A101

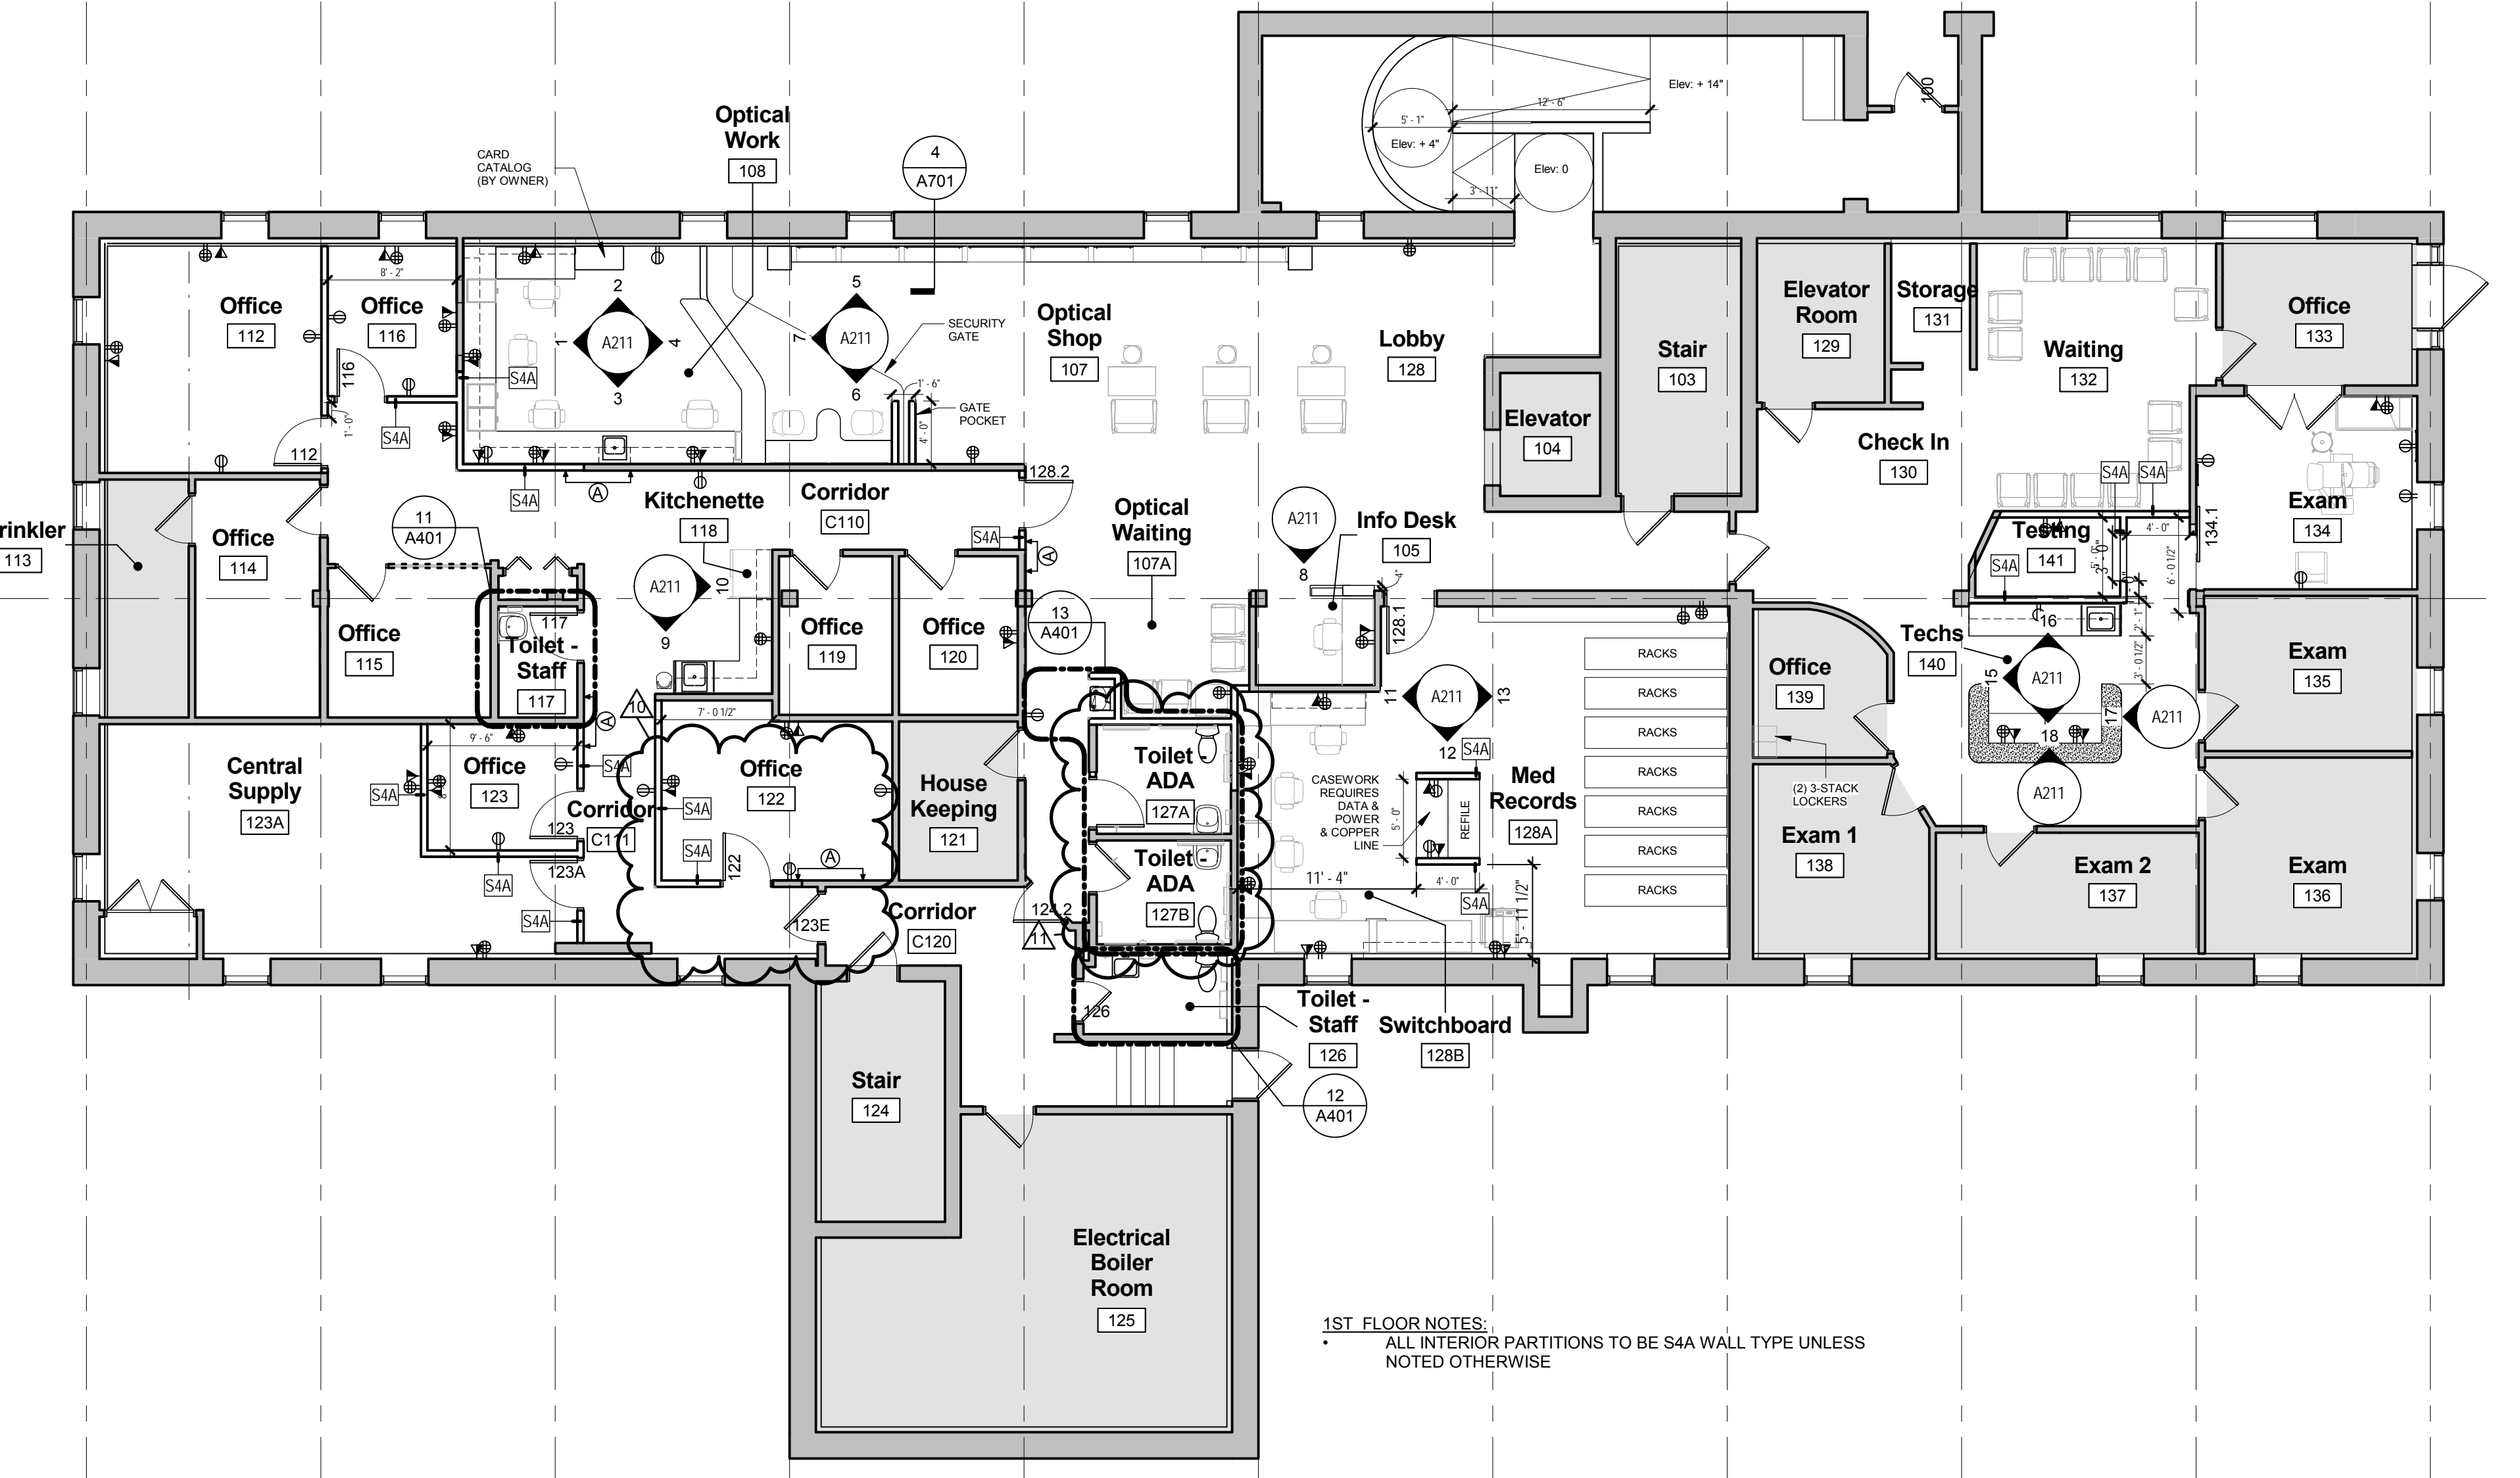
Regarding our conversation yesterday, after some investigating it became clear that our drawings did not have the correct ADA sink we have specified. The previously drawn sink was much larger. I have corrected the sinks and adjust bathroom layouts as required to make the first floor ADA bathrooms compliant.

Regarding bathroom 117, this bathroom would not meet ADA and is an existing space, after reviewing the door swing I believe it is better to have the door swing into the bathroom and not out into the path of travel. Please let me know if you have a concern with this door and I can change the swing if you believe it is required.
